22 April 2016

**Modification Application under Section 96(1a) to SSD_6848 Stage 3B
Redevelopment Of Lismore Base Hospital, Lismore**

DRAWING NUMBER: **ACD3003** REVISION: **H**

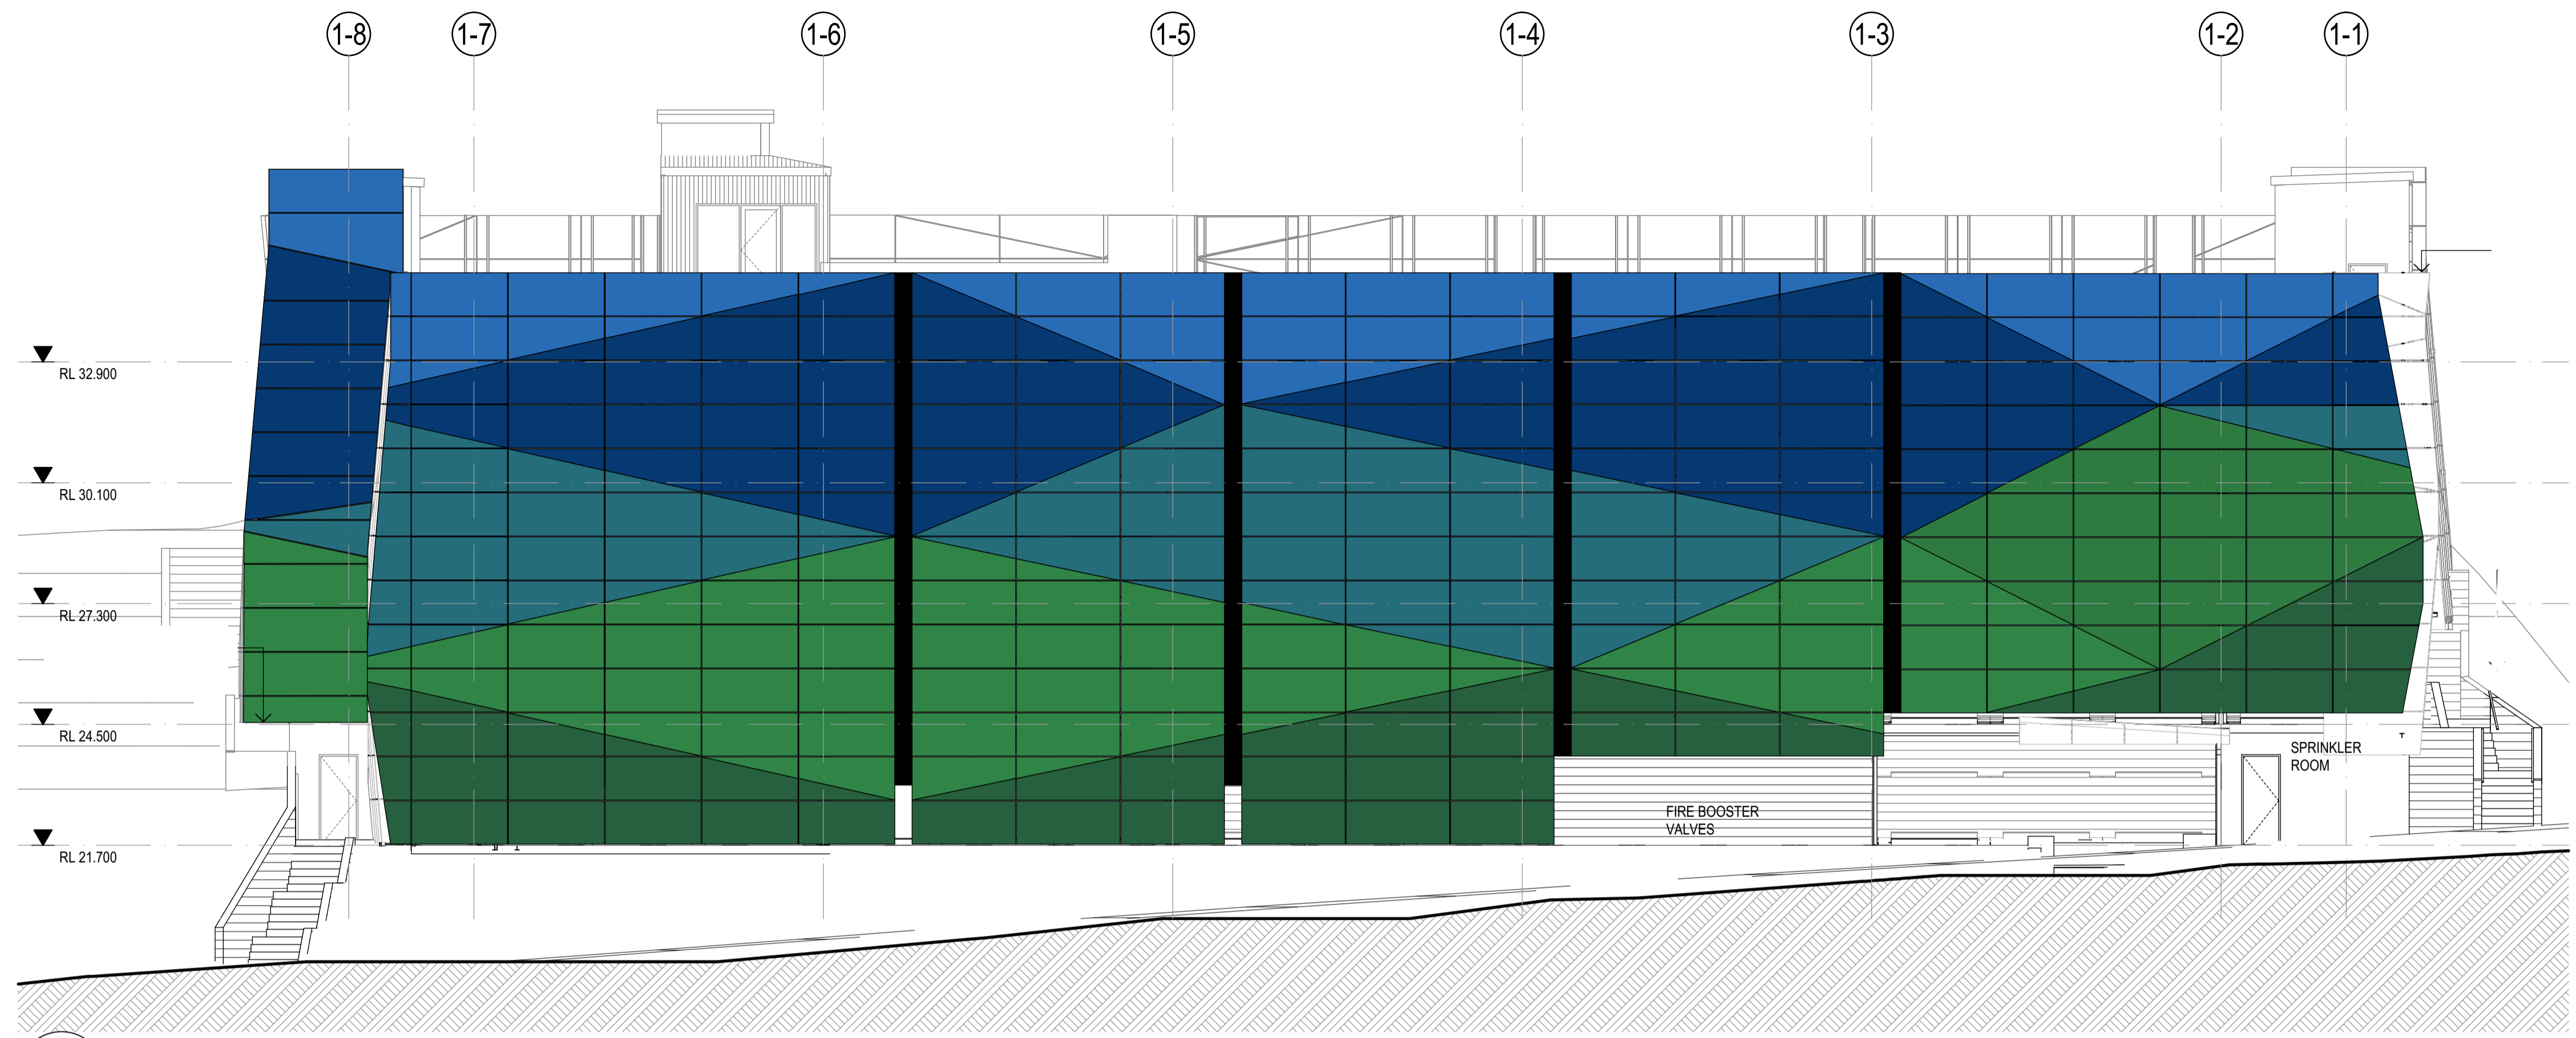
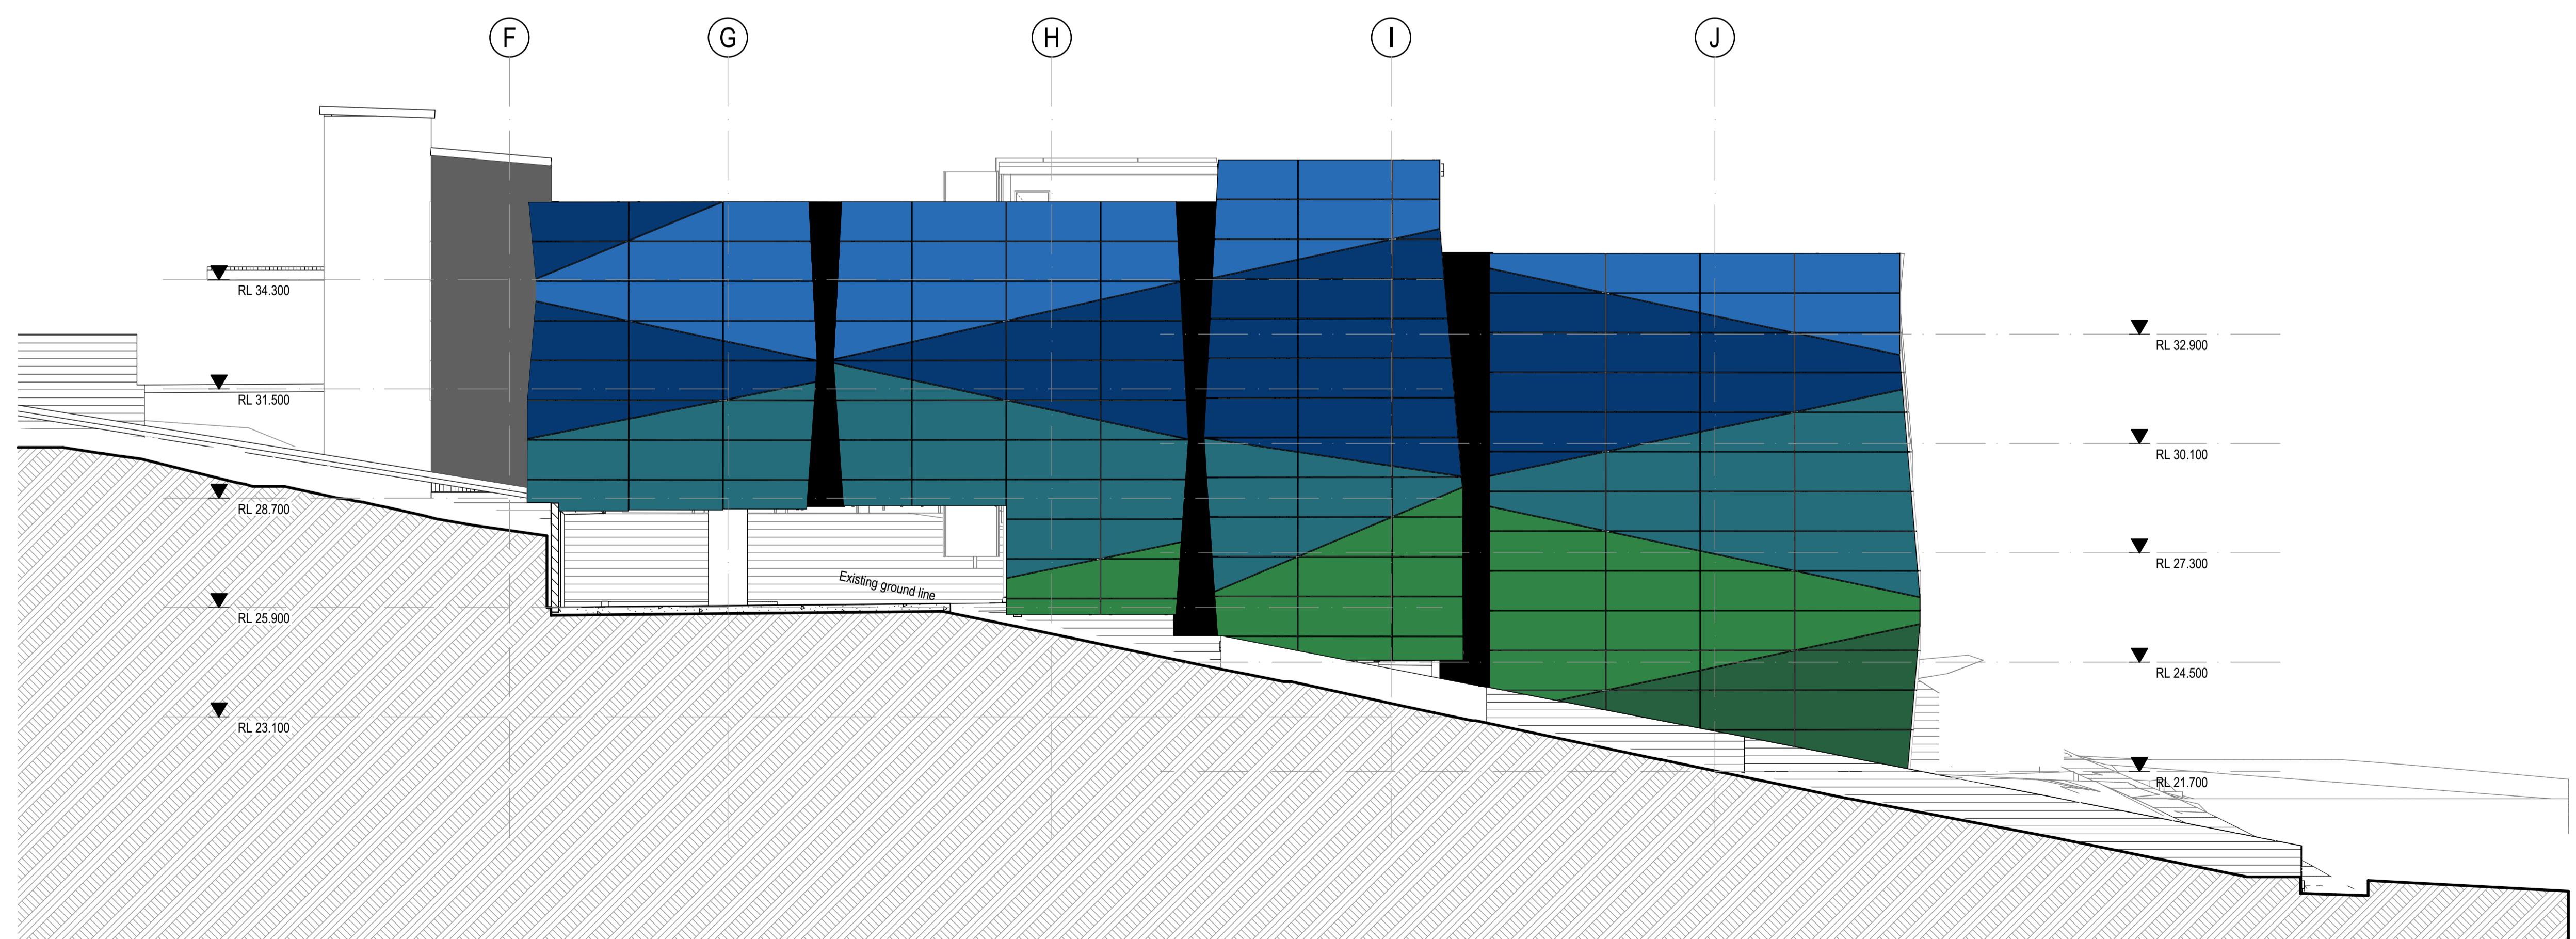
- The façade screen is proposed to be lifted/raised by around 2100-2600mm from the base on the southern and western elevations. The overall height of the façade screen will remain unchanged;

- A vertical colourbond custom orb screen is proposed to the full extent of the western elevation between the lift shaft & the northern façade, from the underside of the lift lobby roof on Level 5 to the point where the lift shaft meets the driveway. It is proposed to delete the section of façade screen to the western elevation to the same area (only previously proposed to Levels 4 & 5);

PROJECT NUMBER 3351L101	DIRECTOR PT	CHECKED
DRAWING NUMBER ACD3004	REVISION	H

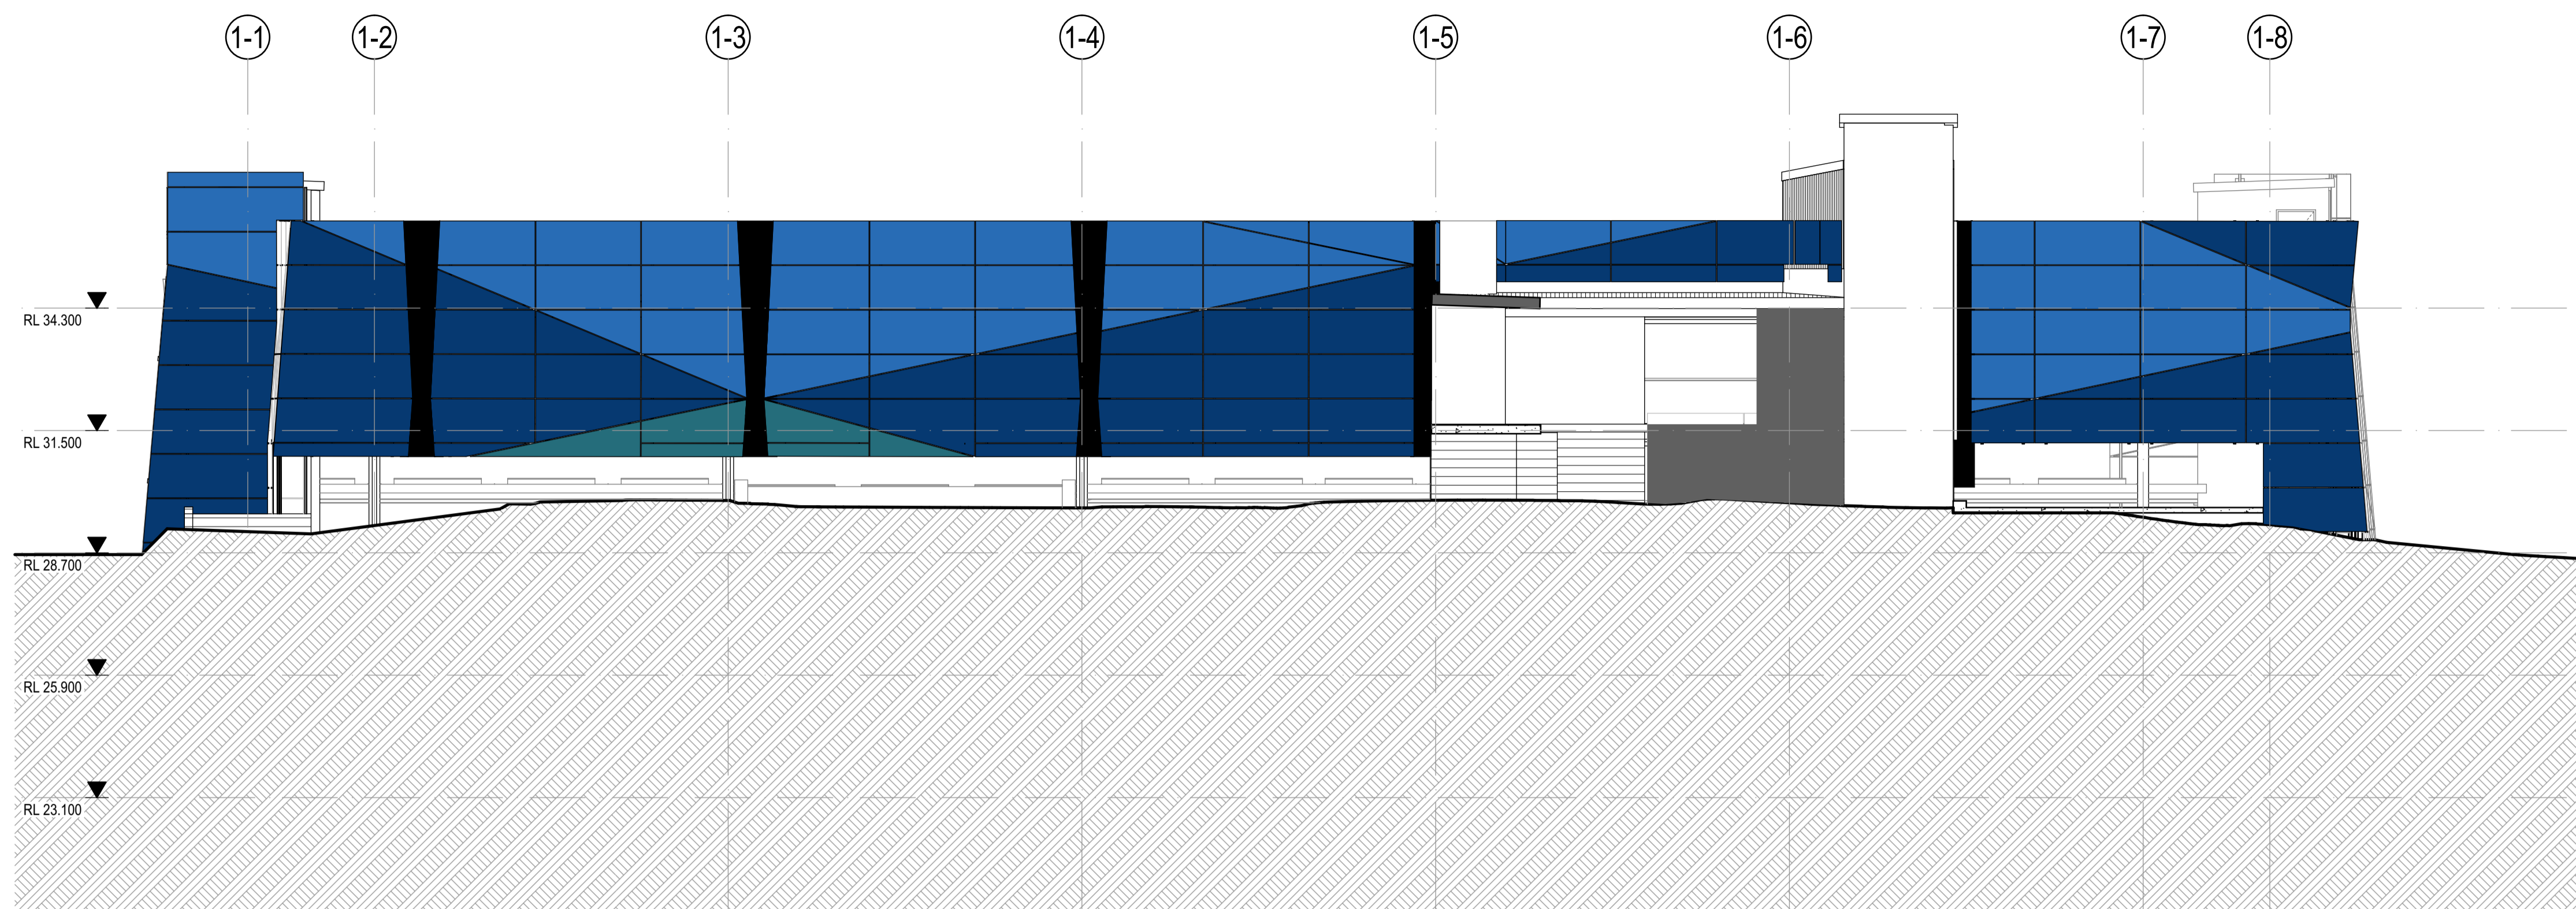
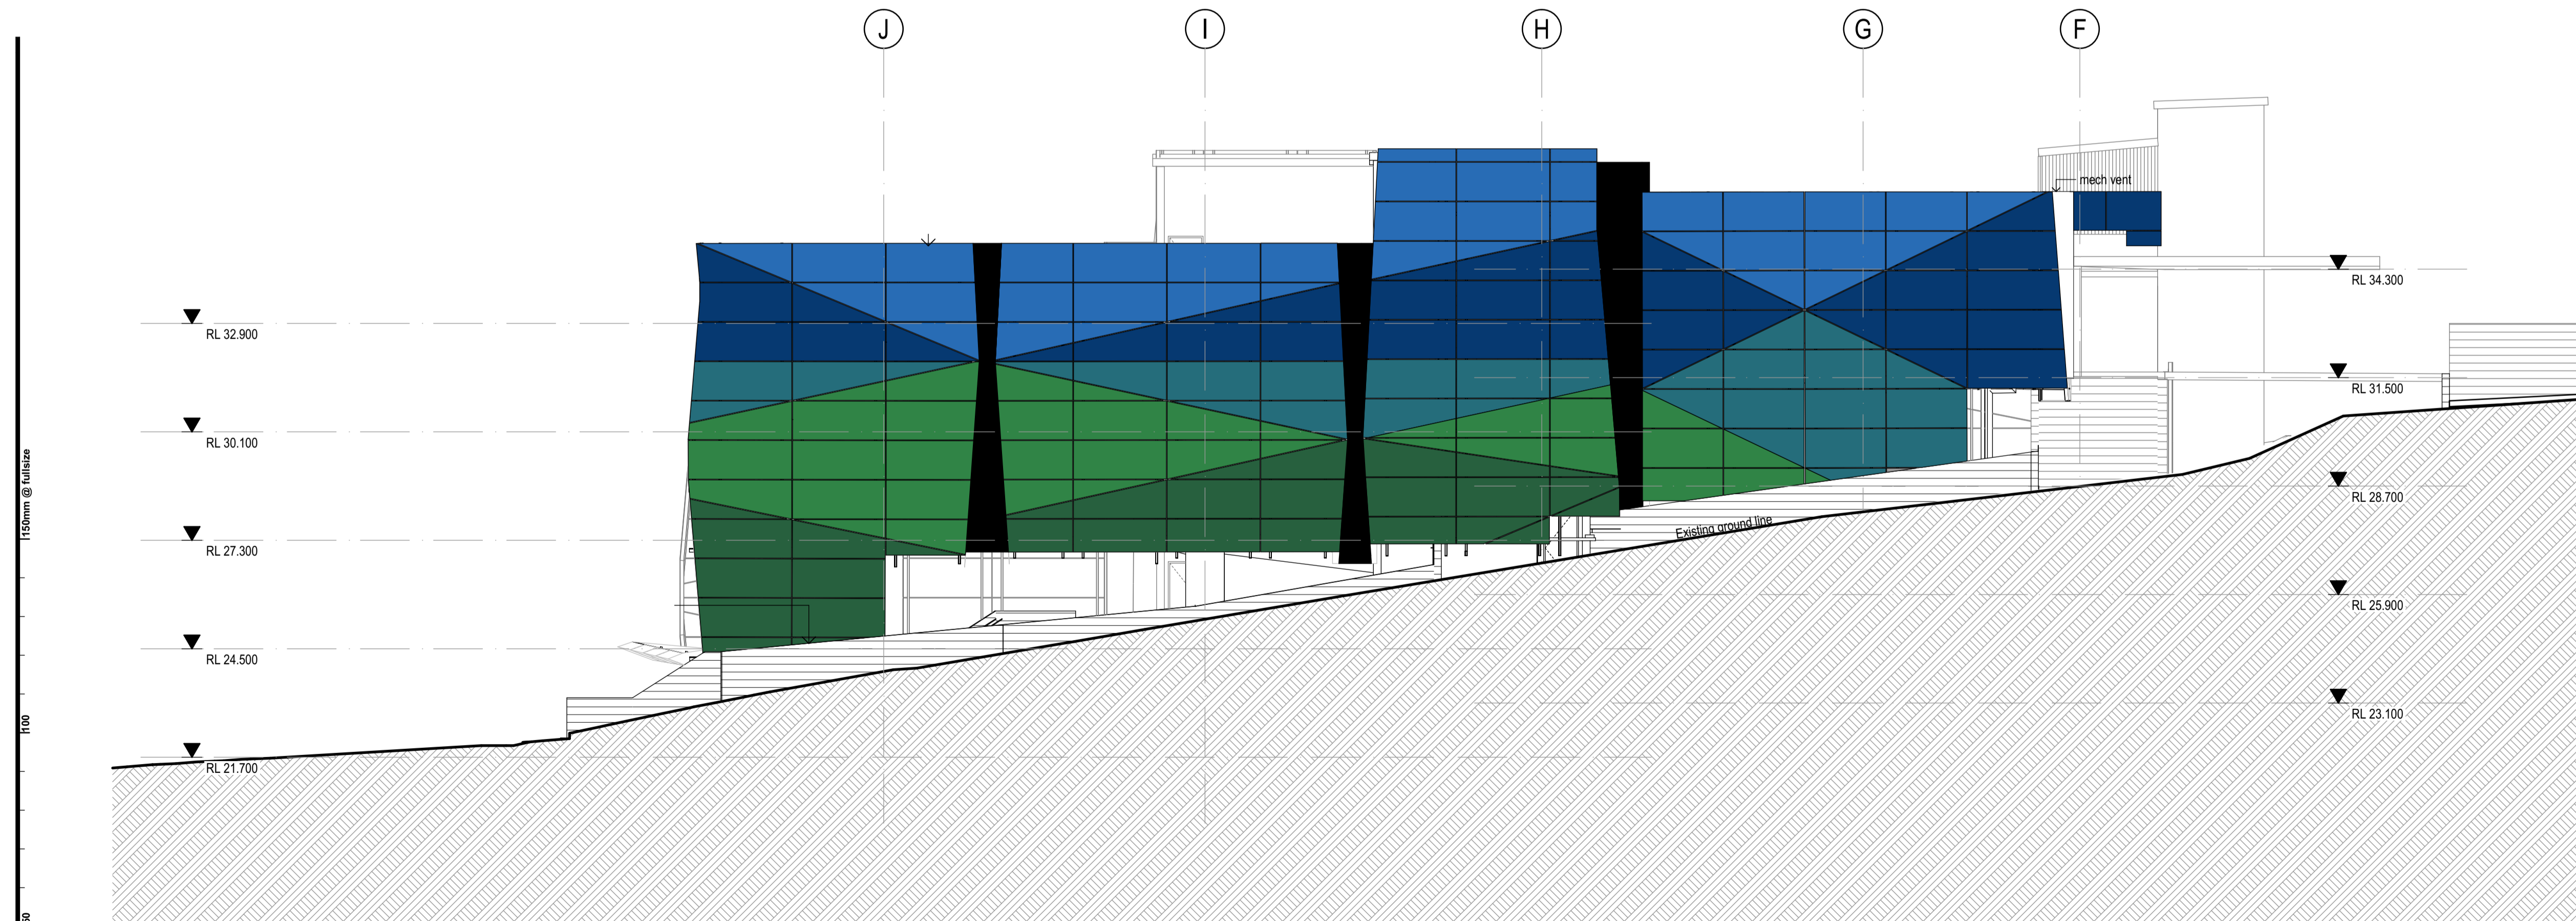
- The material of the northern façade of Stage 1 of the multi-storey carpark is proposed to be amended from a chain wire material to a coloured perforated screen to match the materiality of the other facades;

- A custom orb screen is proposed from the Level 3 slab to the underside of the Level 4 covered walkway roof for waterproofing purposes on the northern elevation (immediately to the east of the lift shaft);

- A small section of façade screen has been deleted from the eastern elevation between Levels 3 & 4, from the lift shaft to the northern façade. There is a covered walkway in this area now, so this section of façade would no longer be seen;
